**Petition #:** 2001-27  
Citiline, LLC and Koutoulas  
**Petitioner:** Custom Builder  
**Hearing Date:** March 19, 2001

**Petition Number 2001-27**

## **Petitions 2001-24 thru 2001-32**

Solid Waste and Groundwater Section Comments, January 17, 2001

# TD1

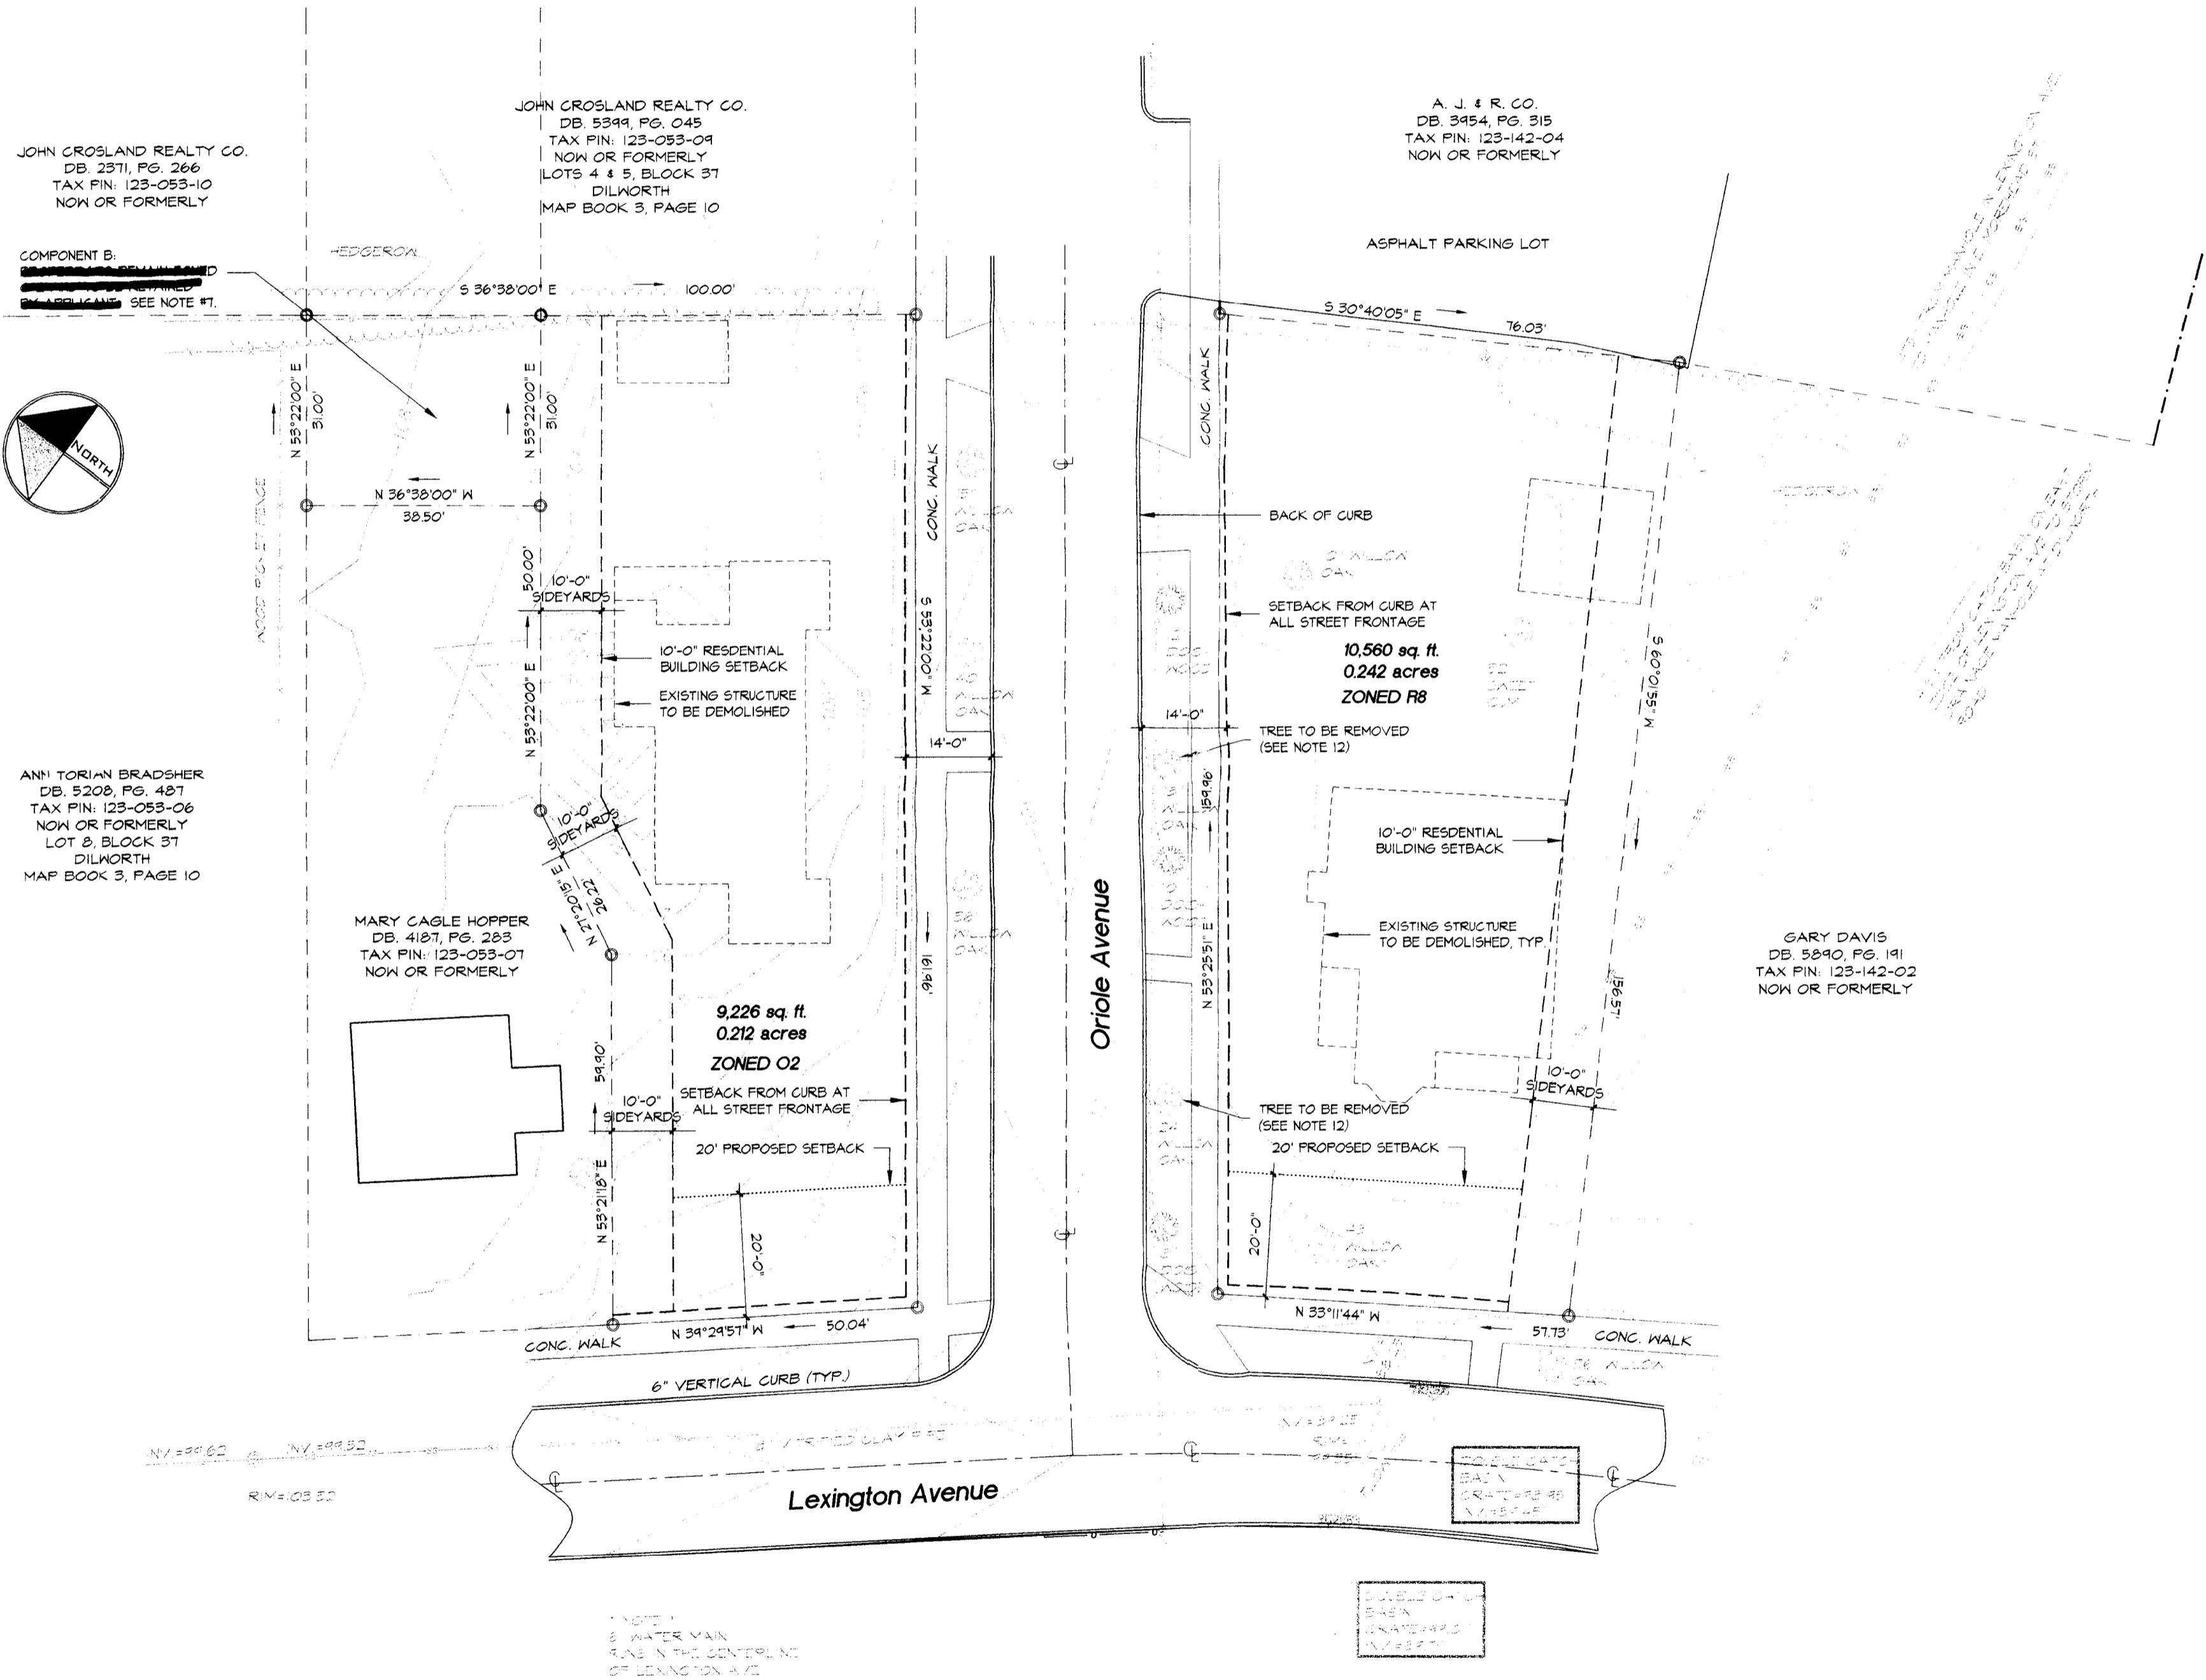
**Comment:** The above referenced properties (tax parcel #s: 123-142-03, 123-053-08) intersect a stream that drains an area greater than 100 acres and therefore require a S.W.I.M. Stream Buffer at a width of 35 feet on both sides of the stream measured from the top of the bank. The plans should indicate the location of this buffer, the three buffer zones, and the top of the bank from which the buffer is measured. Also the plans should indicate the location of the iron pin and orange fabric fencing that mark the outside boundary of the buffer. This buffer must be left undisturbed except for the upland zone where clearing is allowed, but no fill material can be added.
